I have completed the review of this project for building code compliance and have made comments on the attached file(s) for you to address. In addition, please provide information for the following:

City of Portland  
Permitting and Inspections Department

SECTION **A** S1.2 3/4"=1'-0

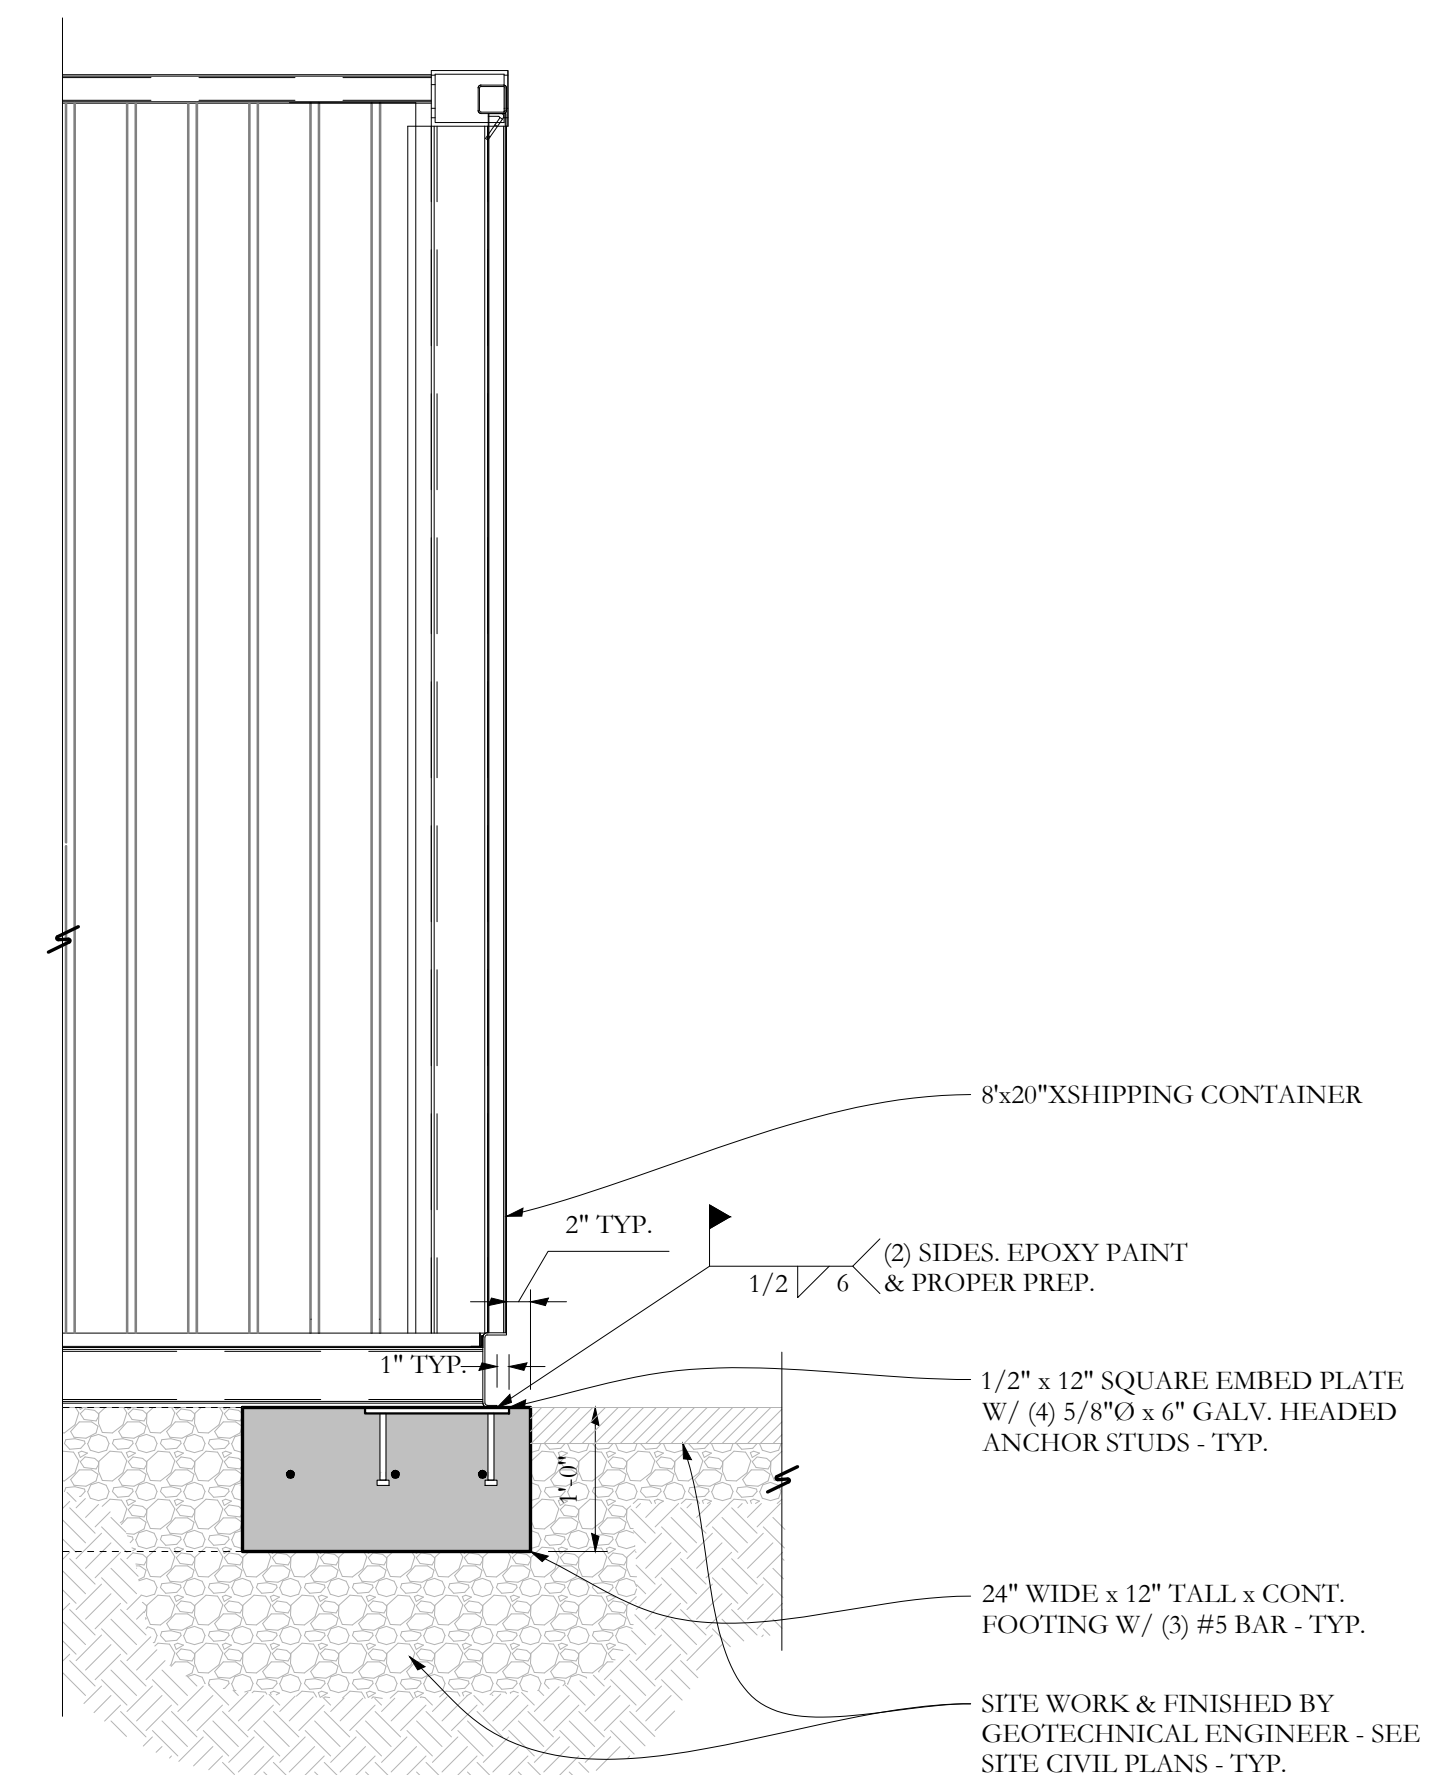
2. Per Section A on plan sheet S1.2 Details, it appears that the floor elevation of the containers will be above the finished grade, please confirm. Per the 2010 ADA Standards, Sec. 225.3 Self-Service Storage Facilities, the minimum number of spaces required to be accessible for over 201 facilities is 10, plus 2% of the total number of units over 200. With 504 units the total number of accessible units is 16. Please provide details and information, including accessible routes, entrances, door operation and hardware and parking spaces.

The finished floor will be higher in elevation than the finished grade to prevent water intrusion. Please refer to attachments 6 and 7 further outlining the ADA-compliant units. There are now 18 accessible units with a half-inch lip in between the finished pavement grade and the finished floor elevation compared to the 6 inch lip on the majority of the other storage units. A 5-foot landing will be provided adjacent to the accessible units. Additionally, the running slope leading to the landing will be less than 5% and the cross slope will be less than 2%.

As approved by the Planning Department, the number of striped parking spaces was waived due to the available parking adjacent to the storage units. This principle applies to the accessible units as well. With a drive aisle of 25 feet, there is ample space for parking and accessibility to the storage units.

Furthermore, the units will have two, 4-foot doors, opening to 8 feet and providing a clear width for ADA-compliant maneuvers. The container manufacturer will be notified that the 18 accessible containers must meet any hardware requirements for ADA-compliant doors.

UNIVERSAL STORAGE CONTAINERS®
The Leader in Portable Container Solutions

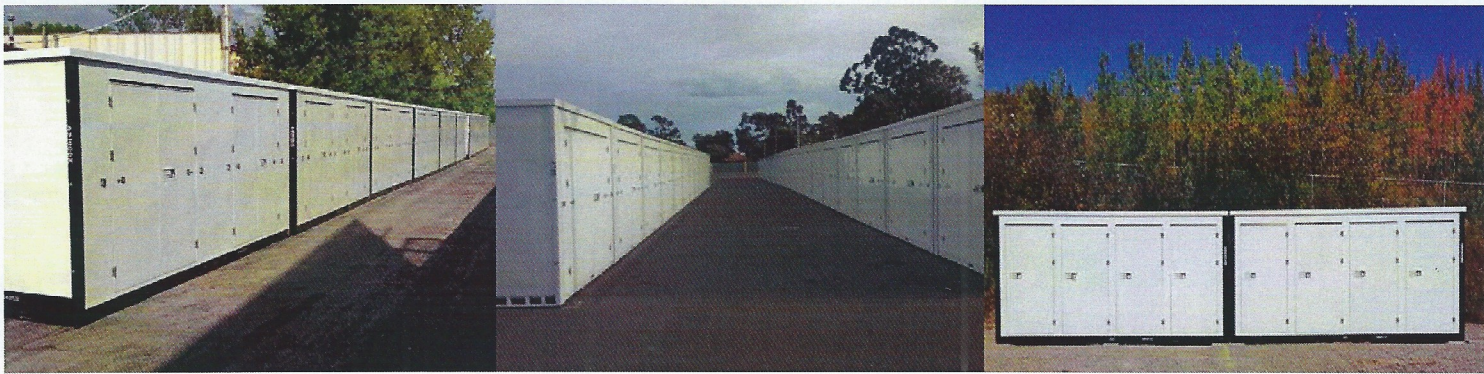
1. Shipping container information/details including any modifications, door operation and hardware.

Two models are currently being analyzed. Once a model is confirmed, the manufacturer's details will be relayed to the City.
